**[FWD: first response from Portland building inspection]**

Subject: 89 Pleasant Ave., PI, BP#2017-01190 plan review comments
From: Jeanie Bourke <jmb@portlandmaine.gov >
Date: Tue, September 26, 2017 4:01 pm
To: "rory@thesellersplace.com" <rory@thesellersplace.com>, Keri Ouellette <k ouellette@portlandmaine.gov>

I am in review of this permit for building code compliance and have some comments for you to address in order to continue with this review. Please provide information for the following items:

FIRST FLOOR

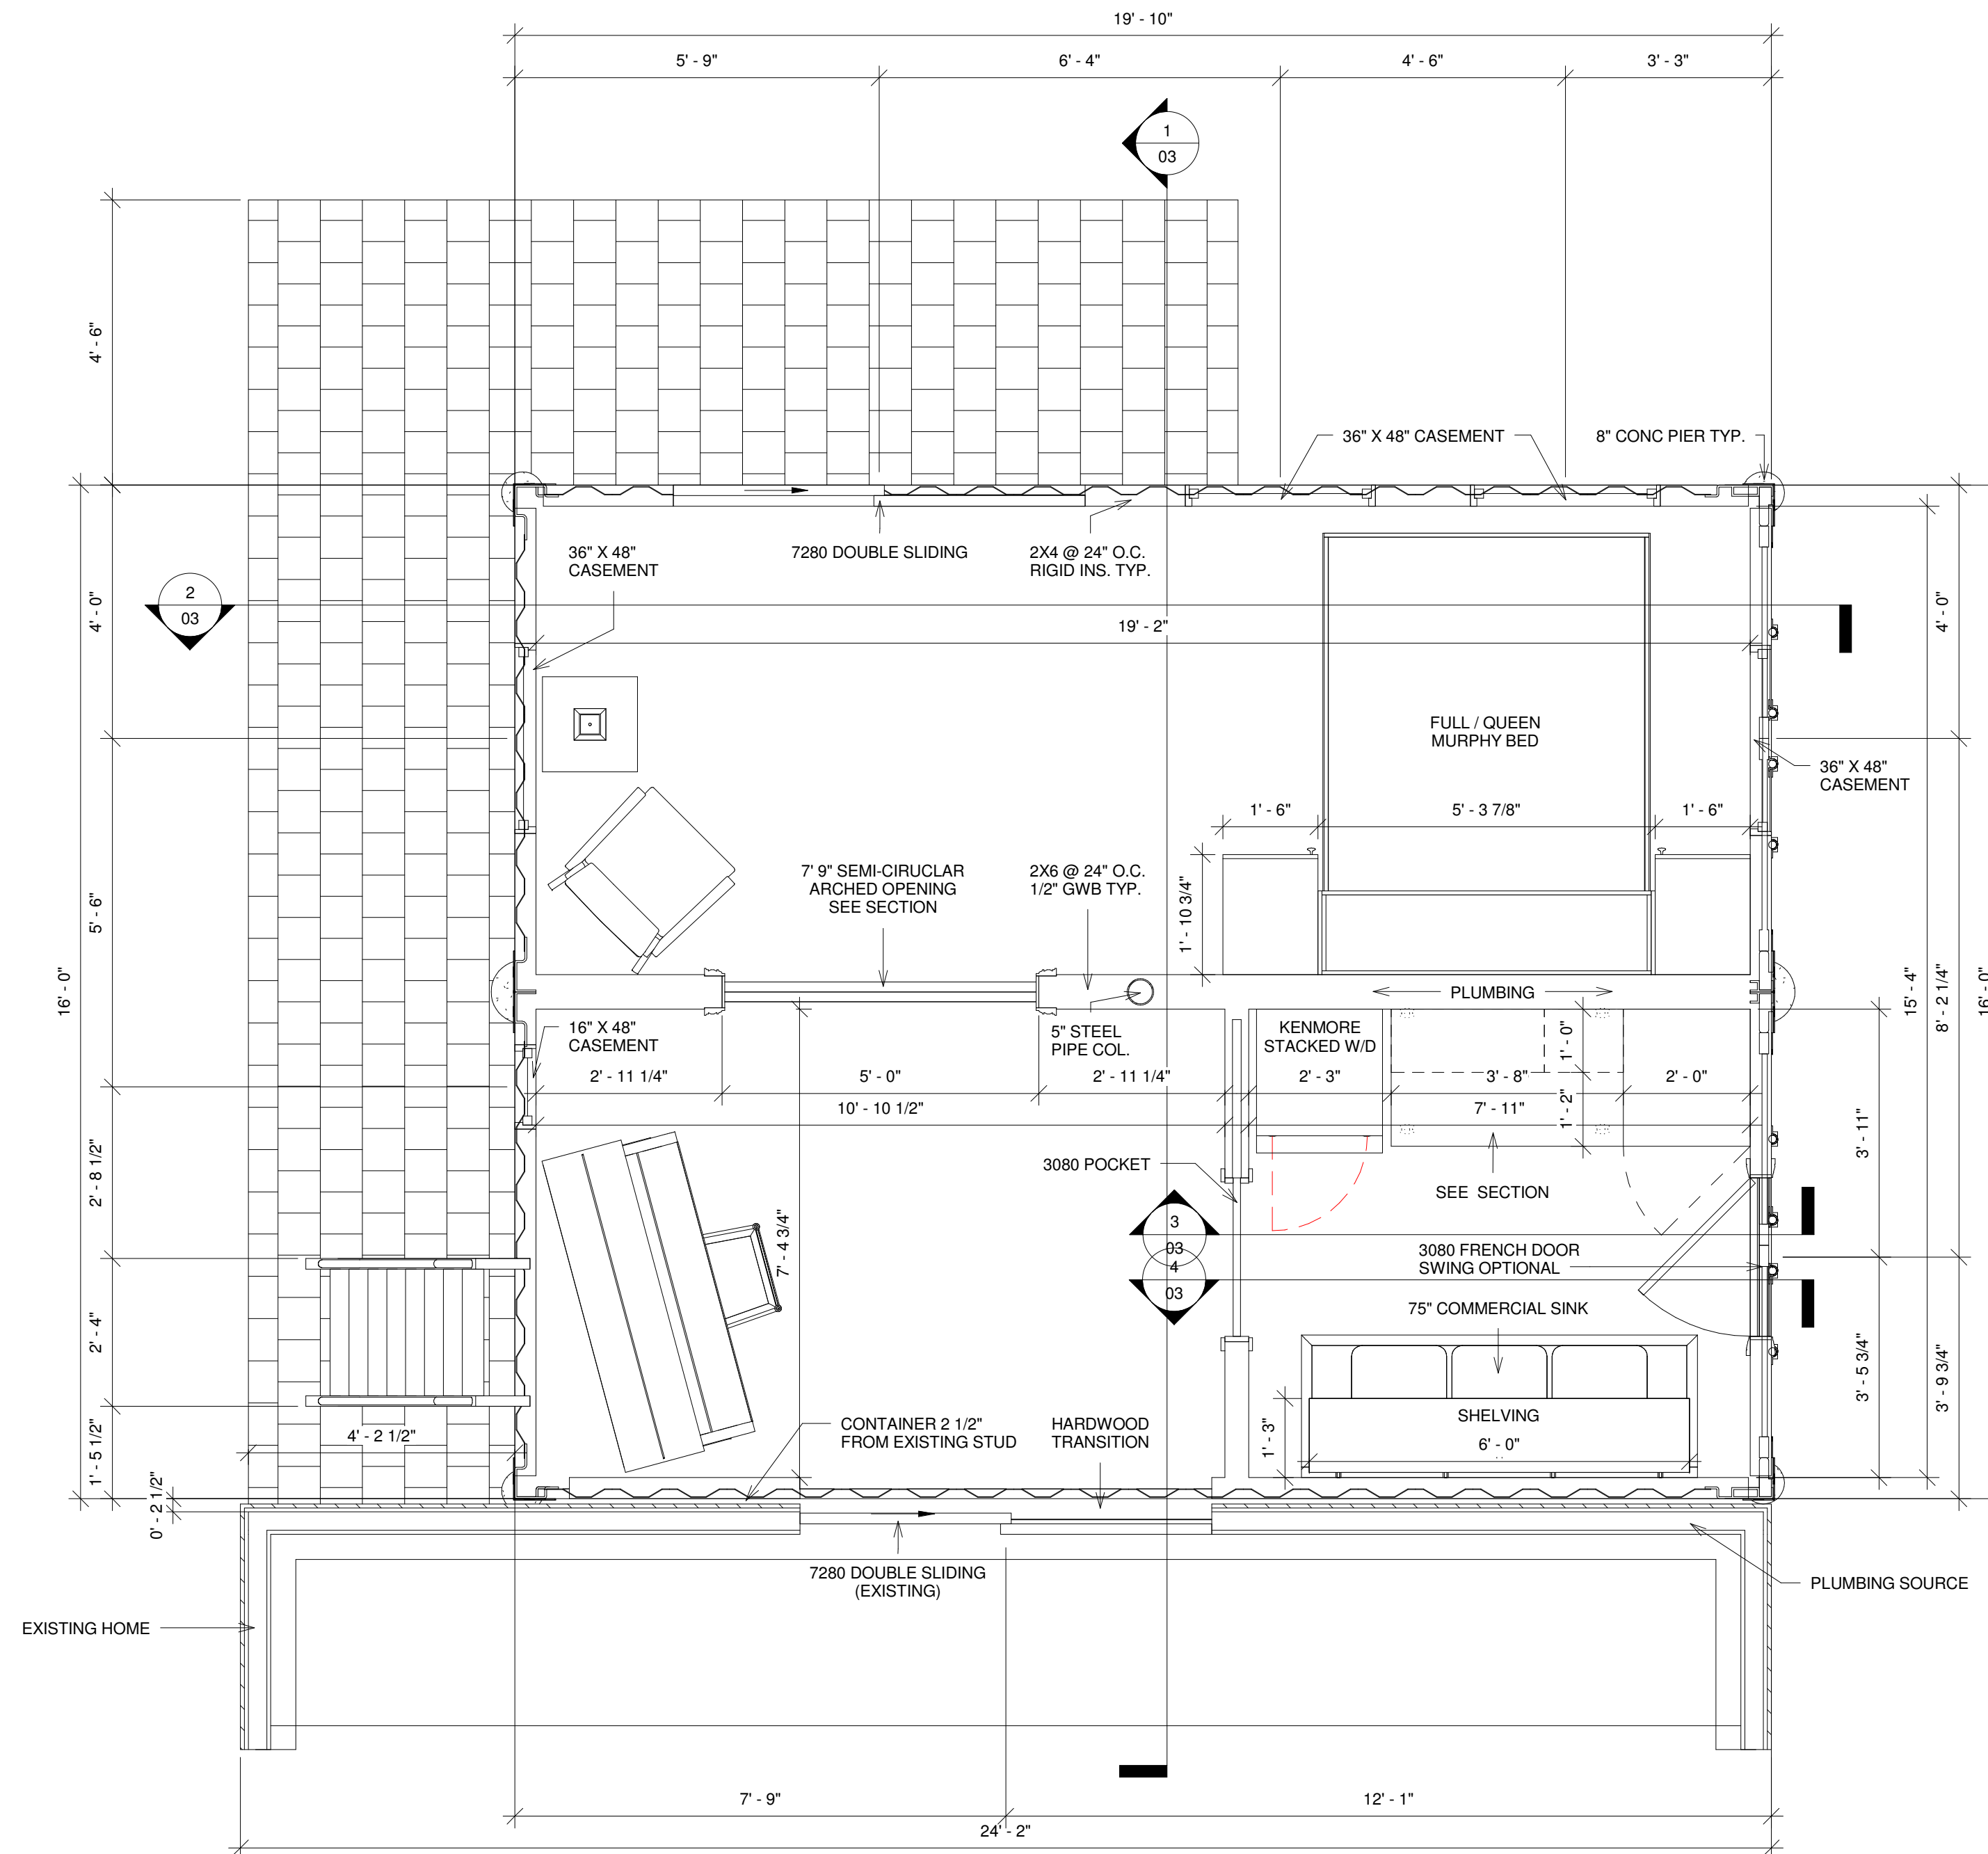
5. Egress from habitable levels shall be by a ramp or stairway per IRC Sec. 311.7, a ships ladder is not an approved means.

TOP CONTAINER

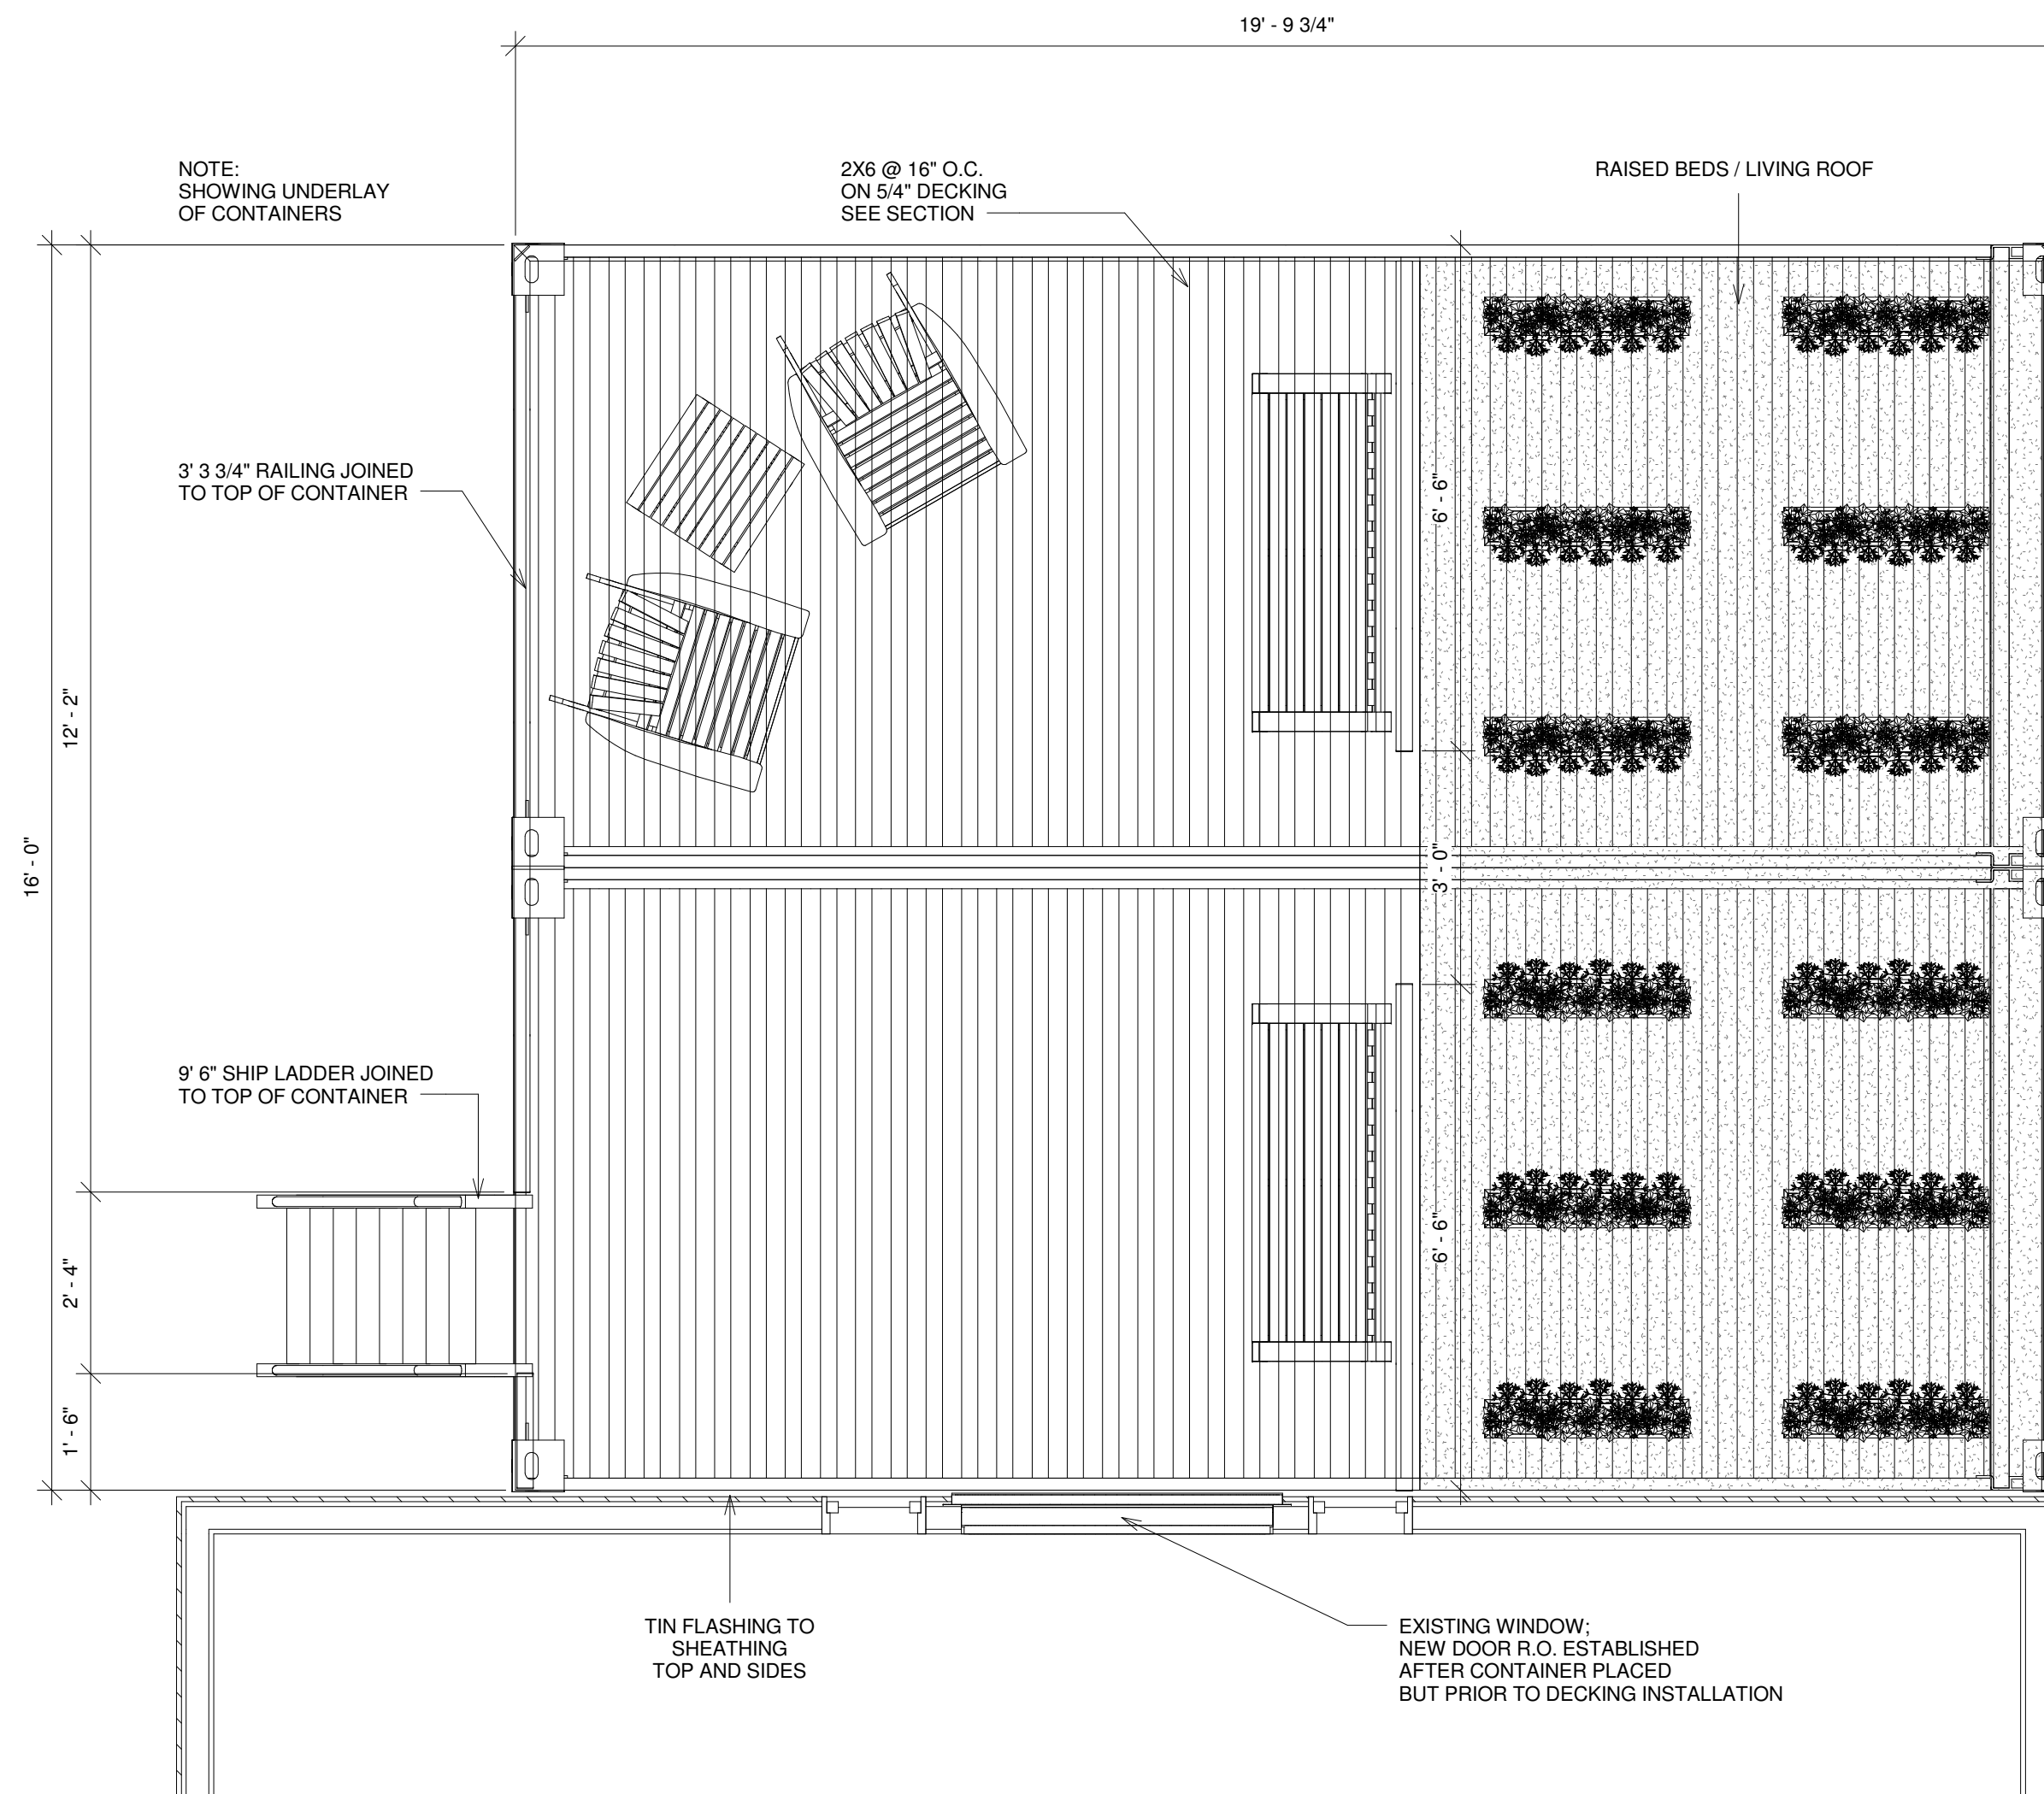
4. Attachment and anchoring details of the addition to the foundation are required, as well as these details for the rooftop deck materials and guardrails. The height of the guardrail is not compliant at less than 36" and opening dimensions are required.
